Consultation Response from KC, Conservation & Design**2024/90116 21-23, 25 and 27 Round Ings Road, Outlane, Huddersfield, HD3 3FQ****Listed Building Consent alterations and renovations to existing dwellings 21/23, 25 and 27; erection of single storey extensions to existing dwellings 25 and 27; partial dismantling and rebuilding of detached barn; conversion and extension of detached and attached barns to form one dwelling; widening/improvements to existing access road, formation of parking and turning areas, together with hard and soft landscaping****Date Responded: 13.3.2024****Responding Officer: Sue Brooks****Responding Ref: HUD 25/1150**

typical external barn screen elevation
the barn unit
scale 1:20

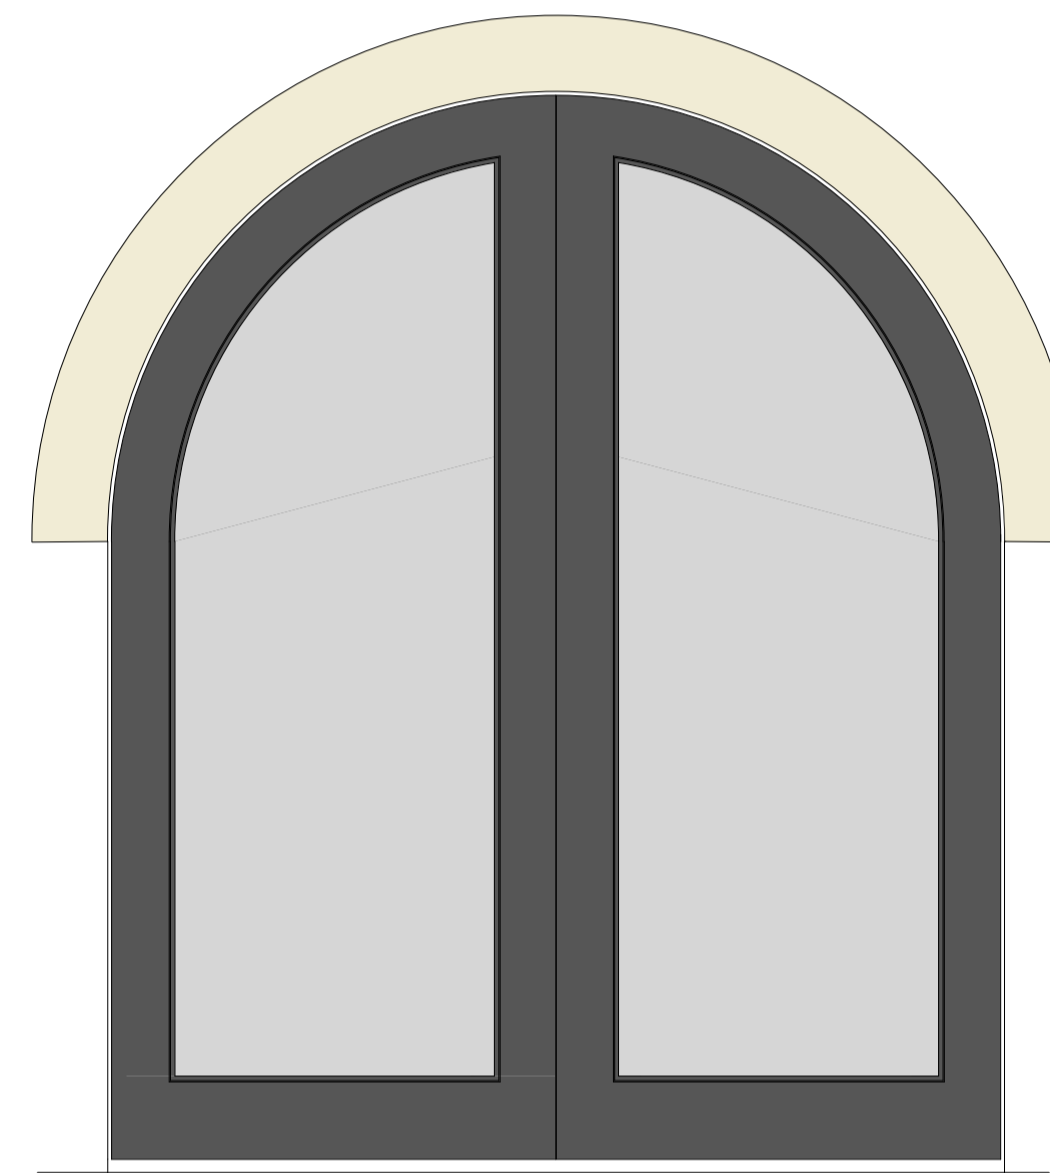
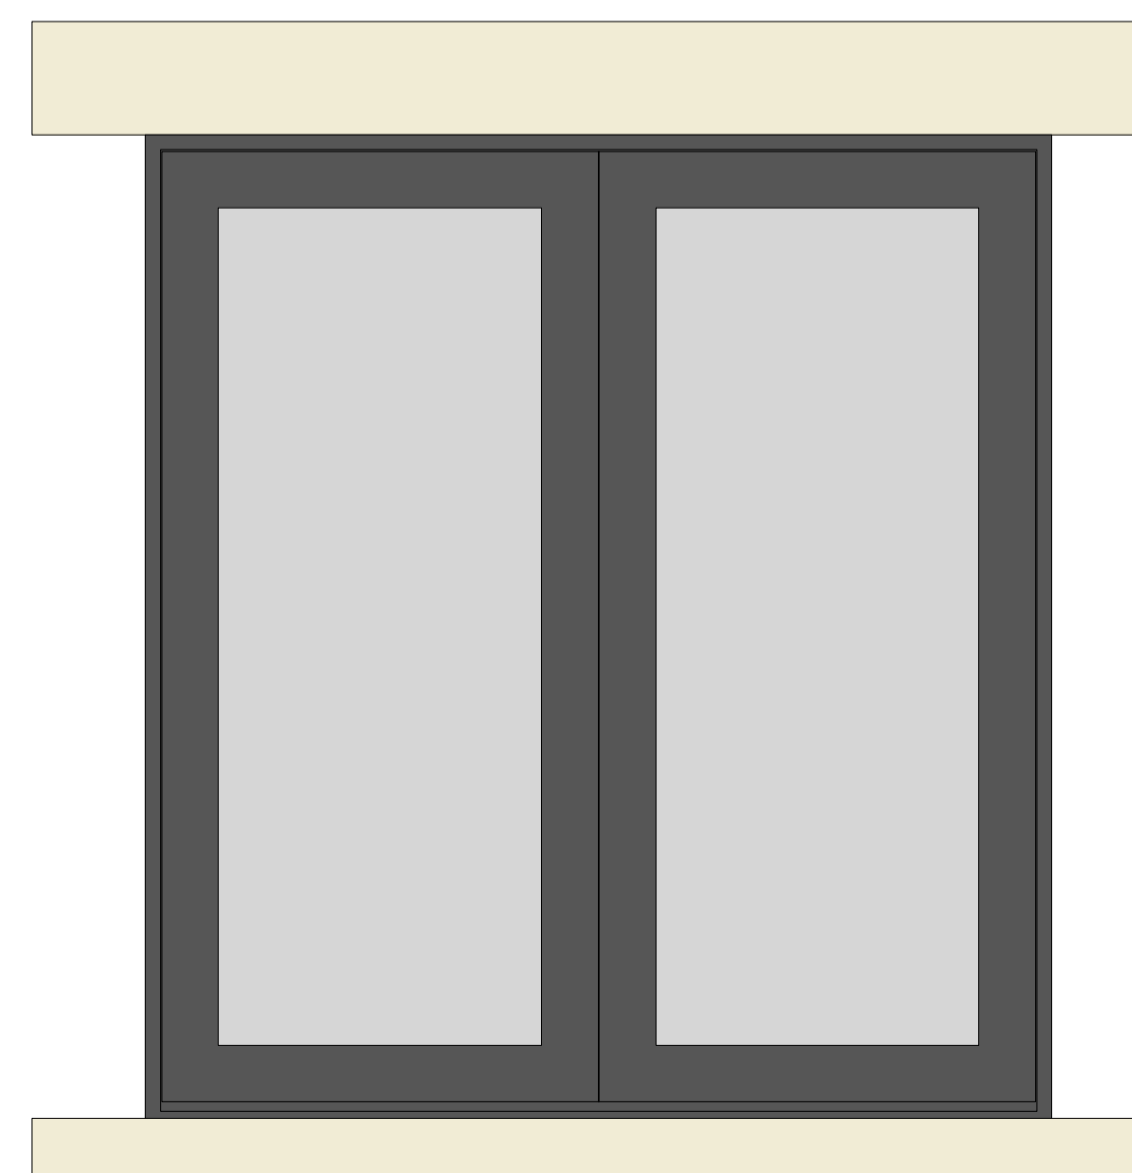
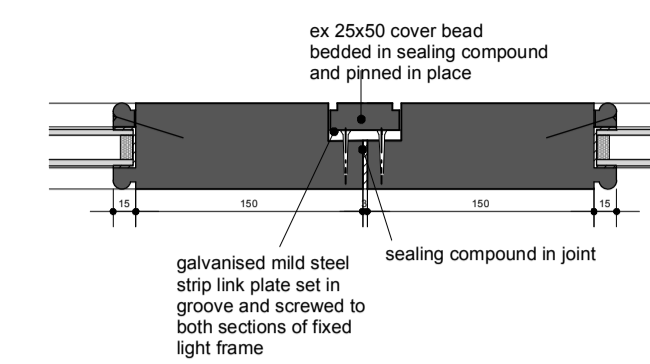
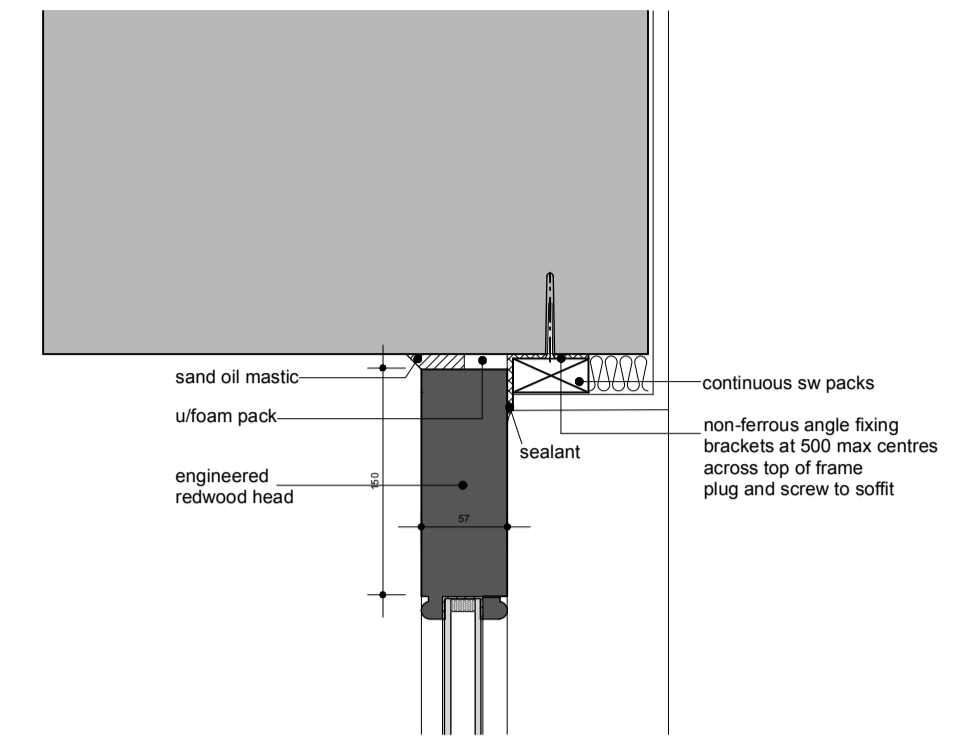
A large timber window is proposed within the existing cart entrance to replace the existing timber doors and replicate a pair of timber framed glazed doors. These are painted black and set back at least 140mm within the reveals to minimise the impact.

Note: As this is a fixed window, we would suggest that the frame sections are slimmer without the central section to reduce the massing. Details of how the first floor will interact with the barn doors are not clear and need to be submitted, along with redesigned cart entrance windows.

The window for this glazed entrance is a large timber framed window designed to replicate a pair of timber framed barn doors. The frames are painted black and set back at least 140mm within the reveals to minimise the impact.

Note: As with the main cart entrance, we would suggest that the frame sections of this fixed window are slimmer without the central section to reduce the massing.
